RE; ENGINEER'S CERTIFICATION FOR FEDERAL PLAZA OFFICE PARK (G-18/D4) RECEIVED DECEMBER 14, 1993 FOR CERTIFICATE OF OCCUPANCY APPROVAL ENGINEER'S STAMP DATED 12-14-93

RE; ENGINEER'S CERTIFICATION FOR FEDERAL PLAZA OFFICE PARK (G-18/D4) RECEIVED DECEMBER 9, 1993 FOR CERTIFICATE OF OCCUPANCY APPROVAL ENGINEER'S STAMP DATED 12-9-93

RE; GRADING & DRAINAGE PLAN FOR FEDERAL PAZA OFFICE PARK (G-18/D4) RECIEVED APRIL 7, 1993 FOR BUILDING PERMIT APPROVAL ENGINEER'S STAMP DATED 4-7-93

RE; GRADING & DRAINAGE PLAN FOR FEDERAL PAZA OFFICE PARK (G-18/D4) ENGINEER'S STAMP DATED 3-30-93; RECIEVED MARCH 31, 1993 FOR SITE DEVELOPMENT PLAN & BUILDING PERMIT APPROVAL

GRADING AND DRAINAGE PLAN

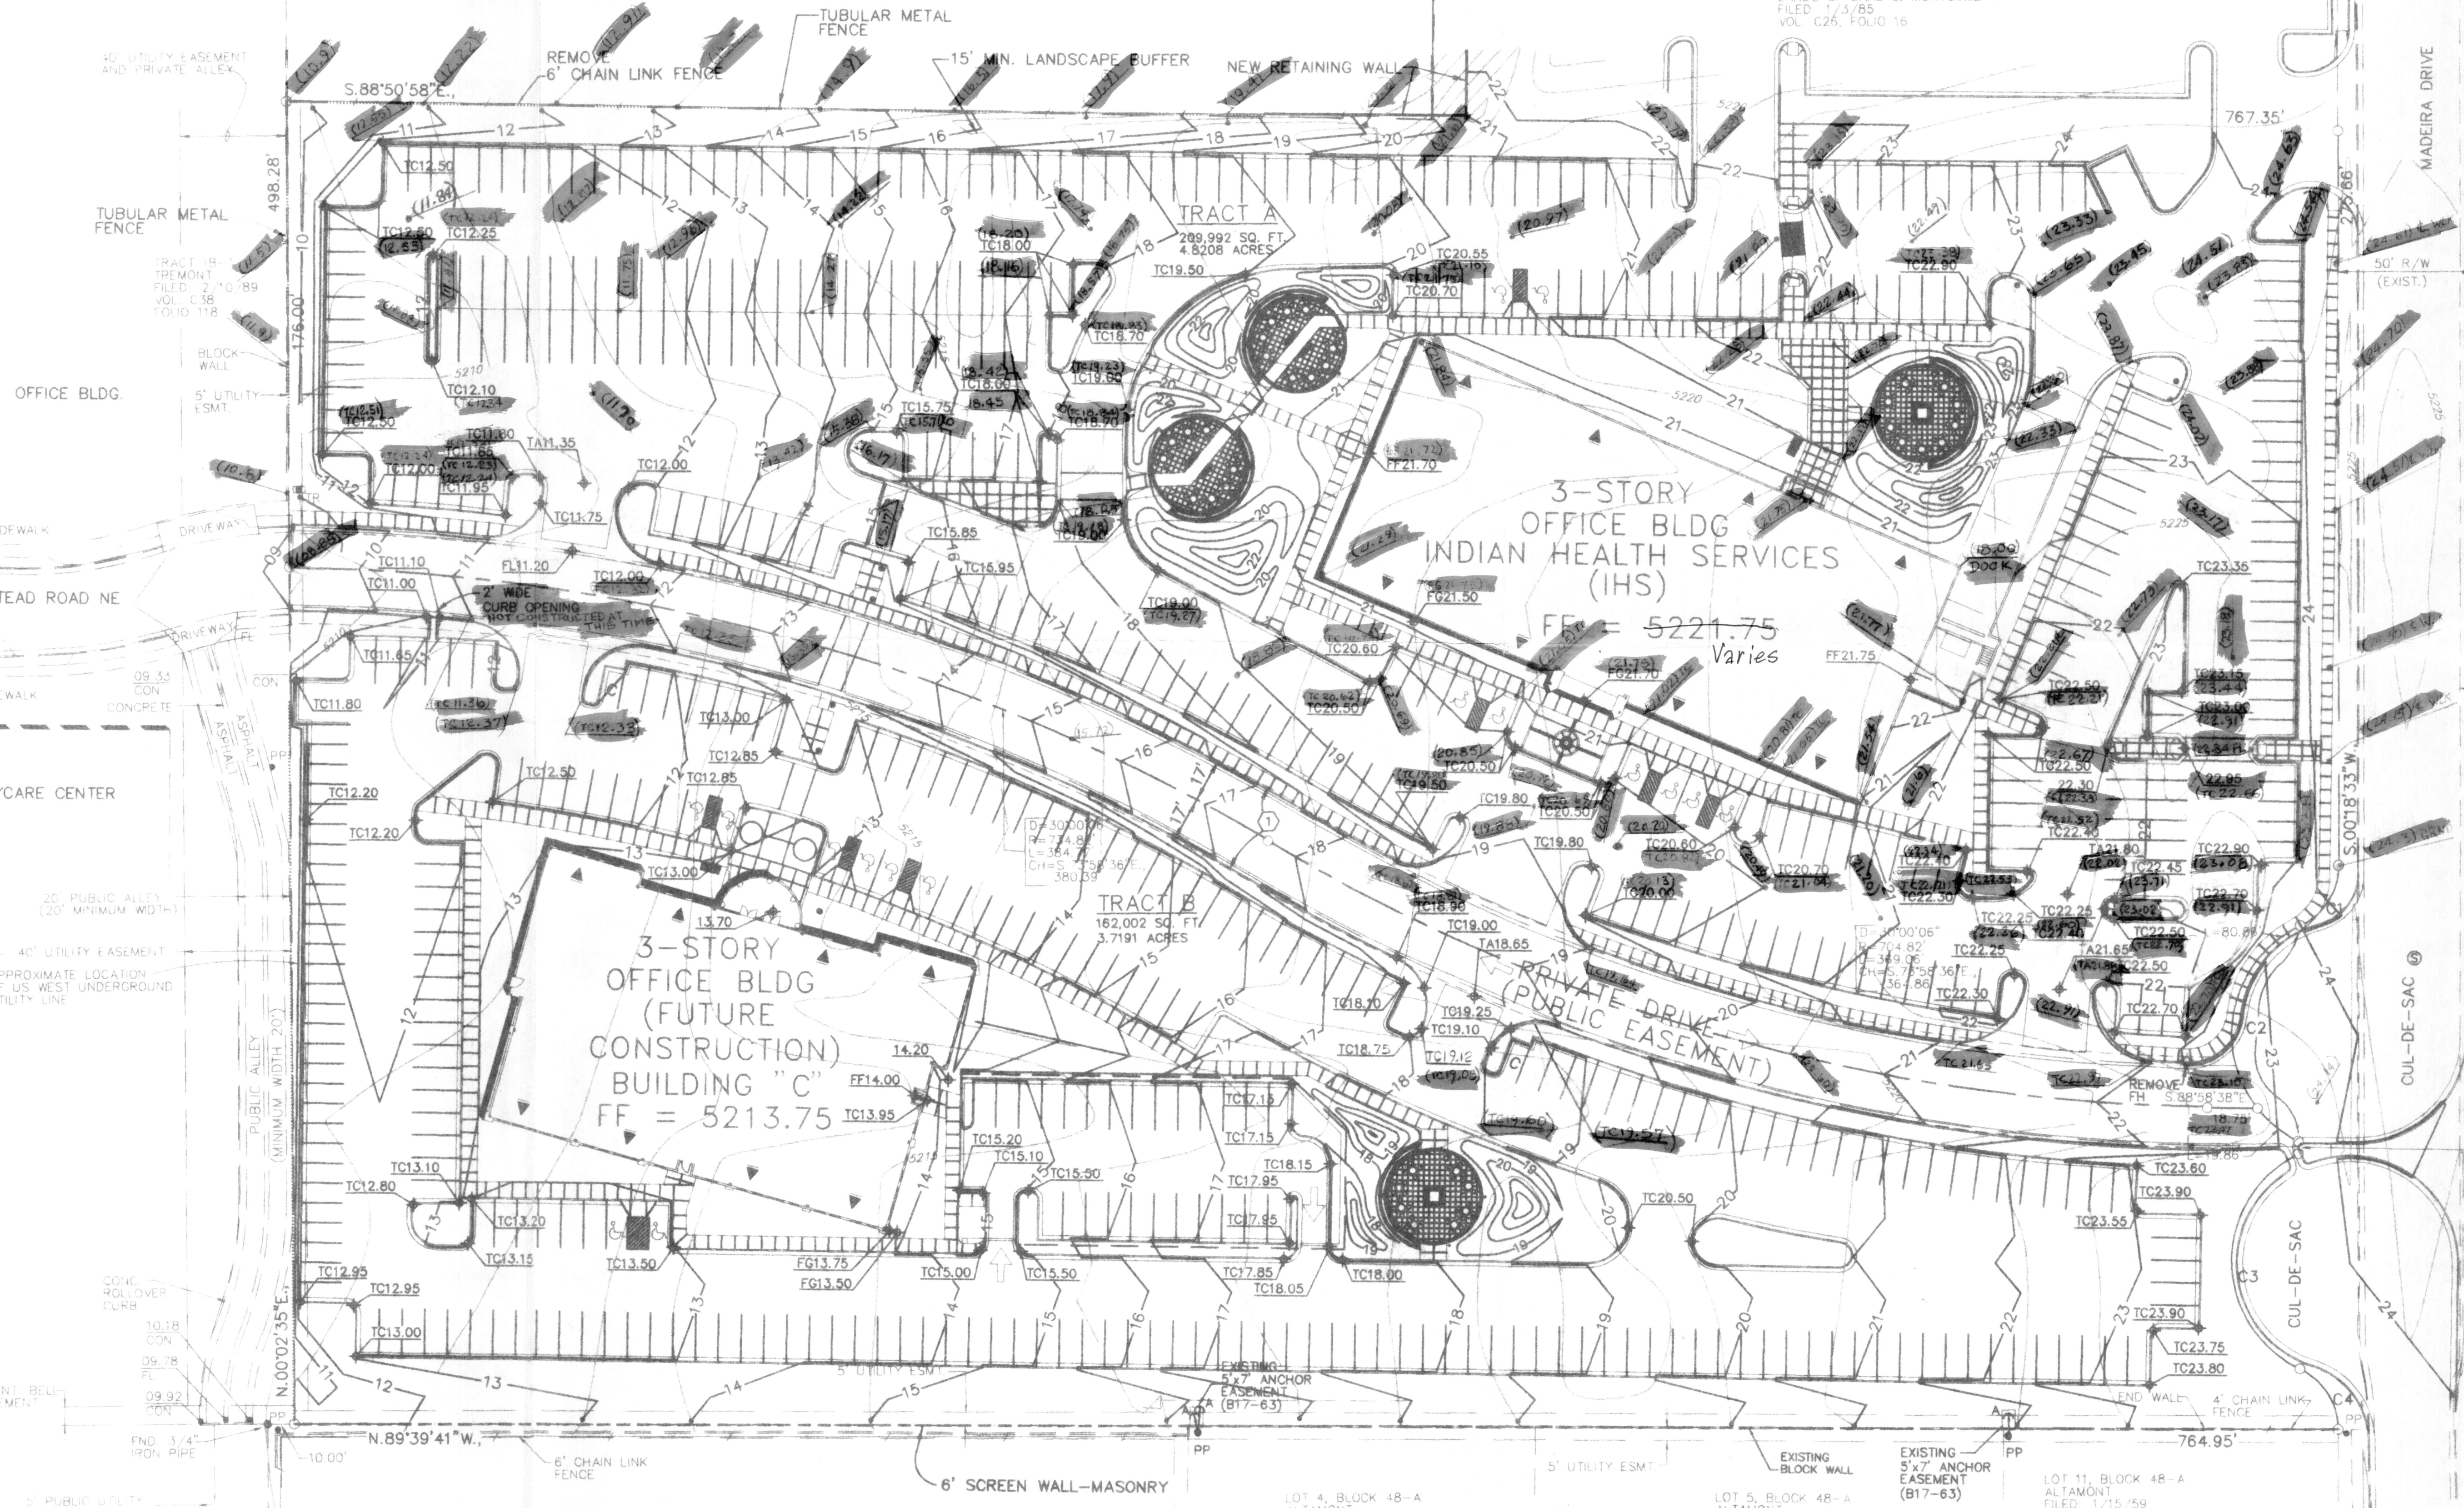
The following comments must be addressed before a Permanent Certificate of Occupancy will be released:

- 1. Include certification statement on the plan per DPM checklist on page 111.
- 2. Clean up as-built elevations. Additional shots where there were no proposed spot elevations tend to clutter the drawing. Clarify that the 18.00 elevation at the NE corner of the building is on the access road for the Loading Dock instead of a finished floor of the Building. As-built elevations at the driveways for Tract B should indicate the extent of construction completed.
